STATEMENT OF RESPONSE TO AN BORD PLEANÁLA PRE-APPLICATION CONSULTATION OPINION

**Proposed Strategic Housing Development
Lands at Back Road & Kinsealy Lane,
Kinsaley, Broomfield, Malahide, Co. Dublin**

Applicant: Birchwell Developments Ltd.

April 2022

DRAWING NO:
PL113

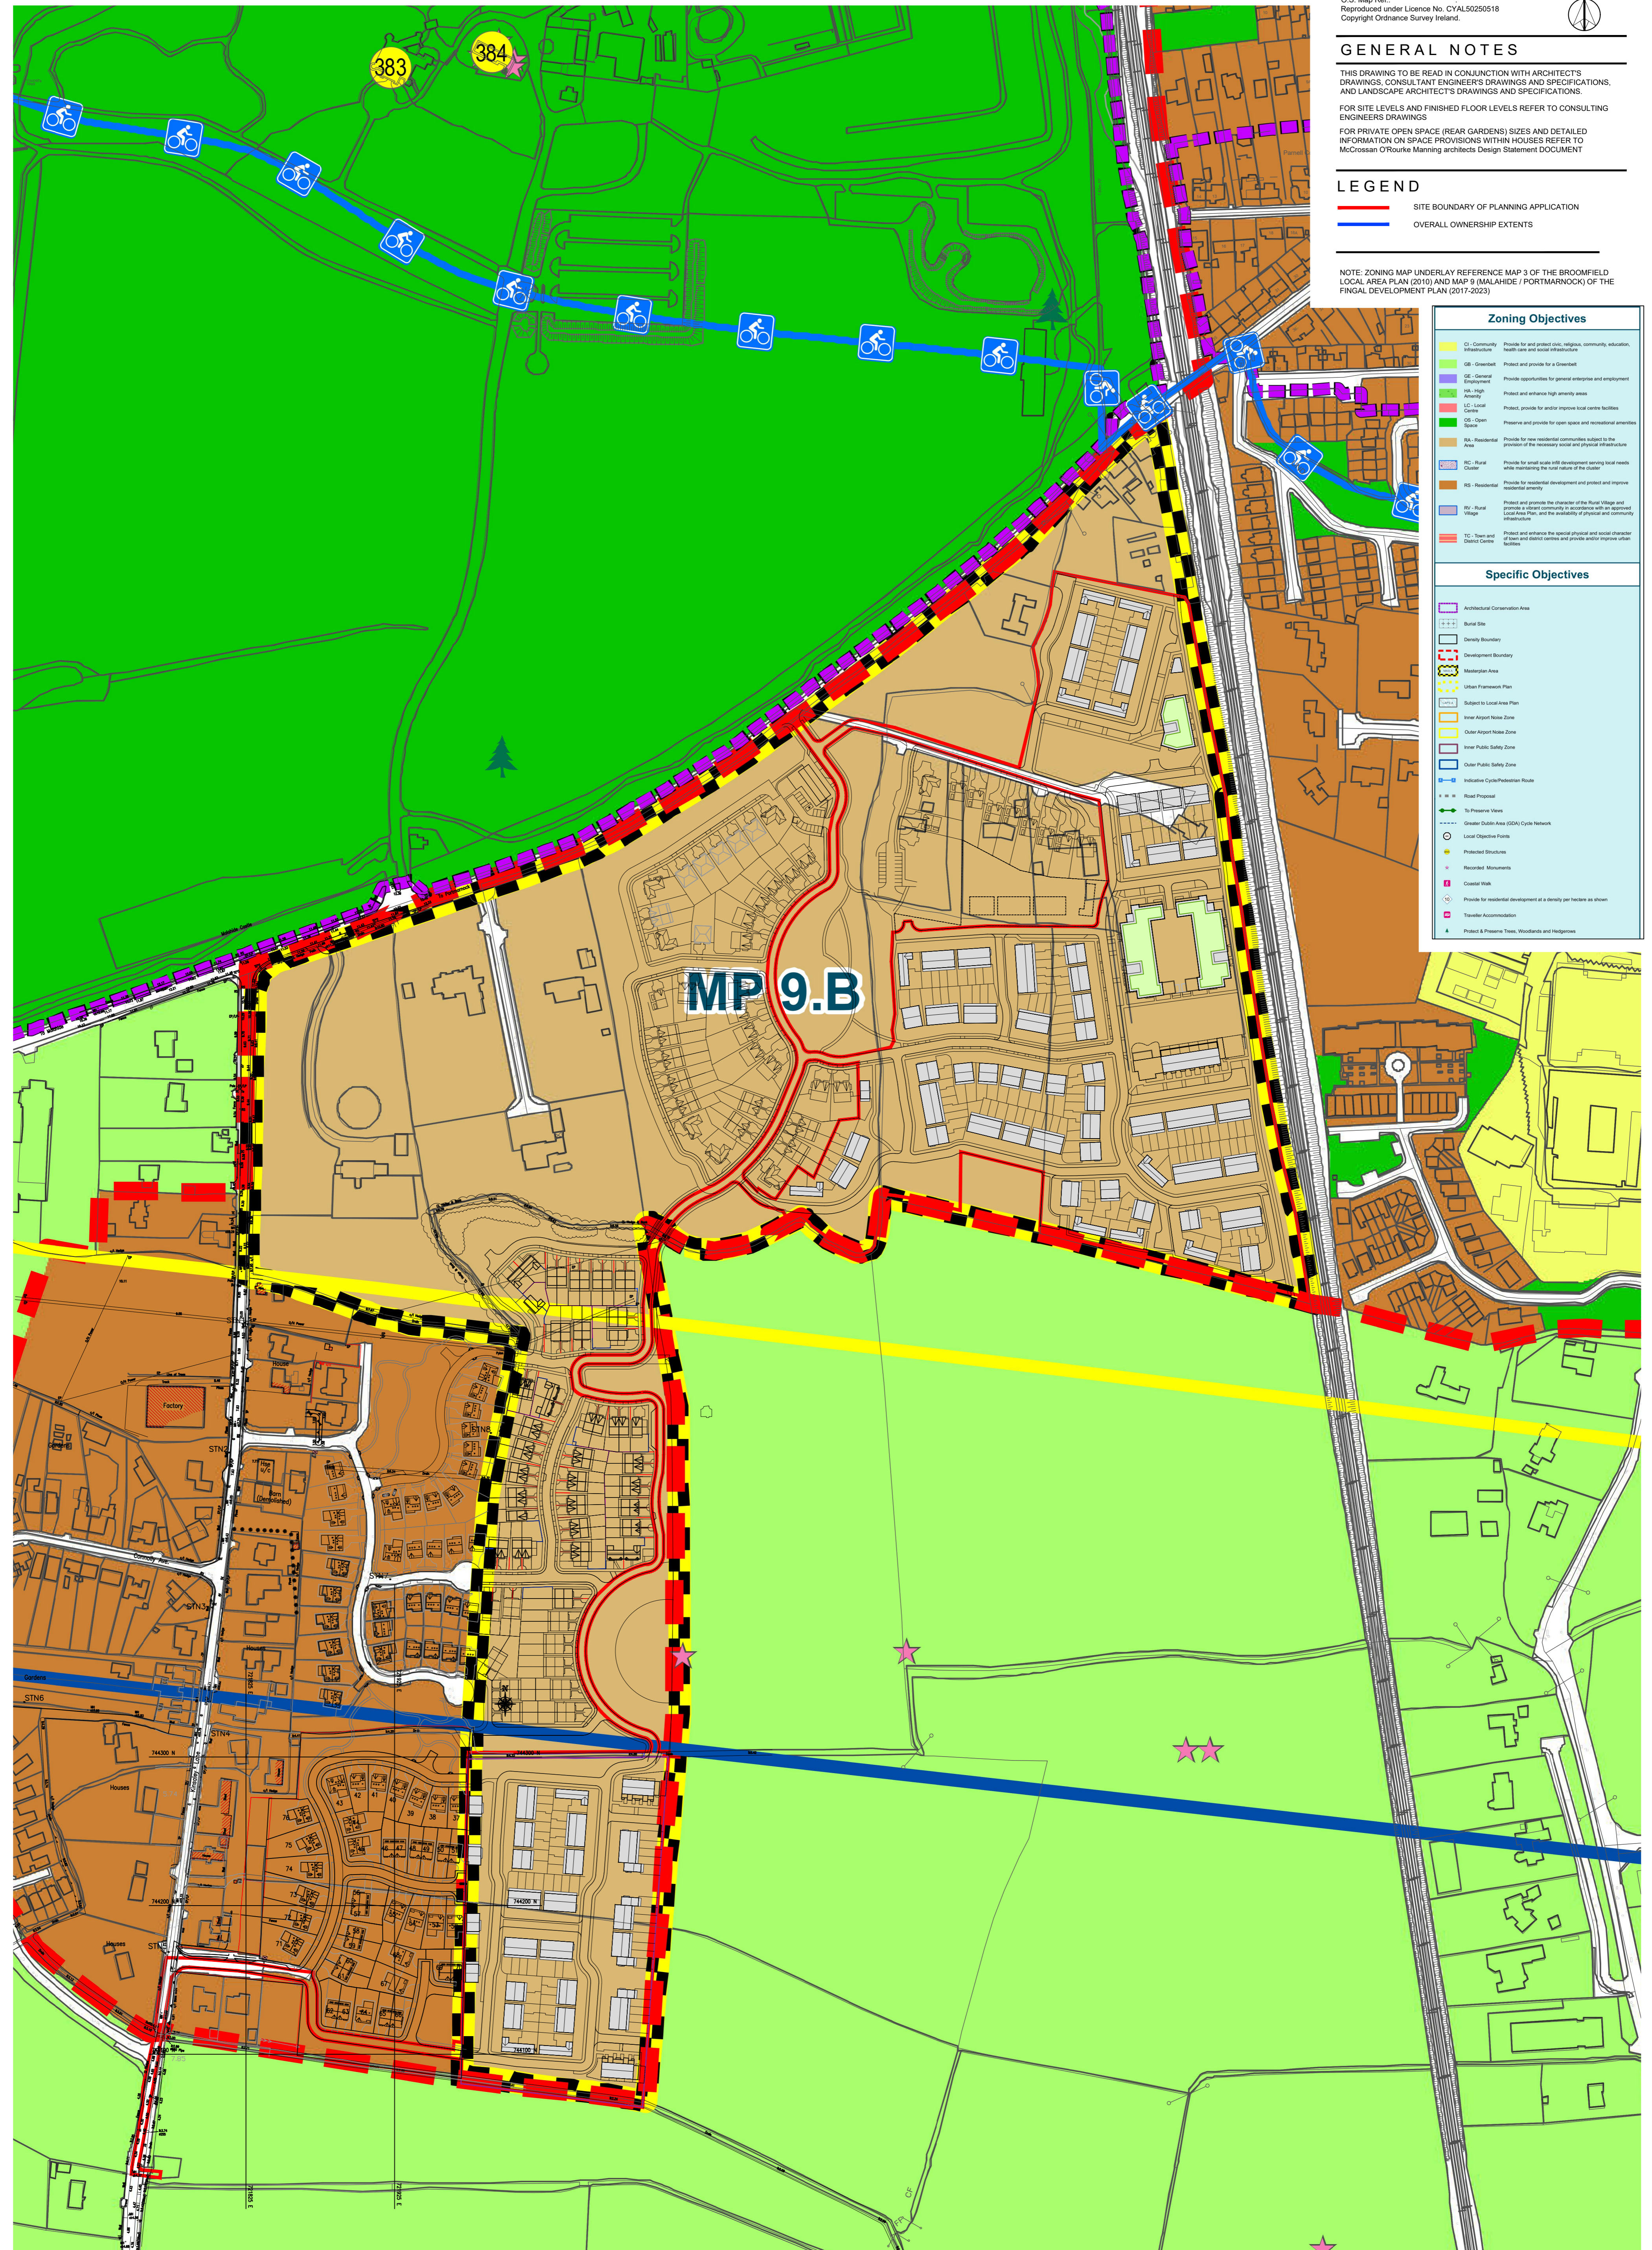
“Further consideration and/or elaboration of the documents in relation to core strategy and the zoning of the site, with a site layout plan overlaid on the zoning map.”

are permitted in principle under the zoning objectives pertaining to the subject lands. The lands are also subject to a masterplan designation, and such a masterplan has not been prepared nor adopted by Fingal County Council. We invite the Board to refer to the enclosed Zoning Objective Overlay Site Layout Plan (drawing 18034-PL113) prepared by MCORM Architect. Also, refer to the Statement of Material Contravention prepared by Downey.
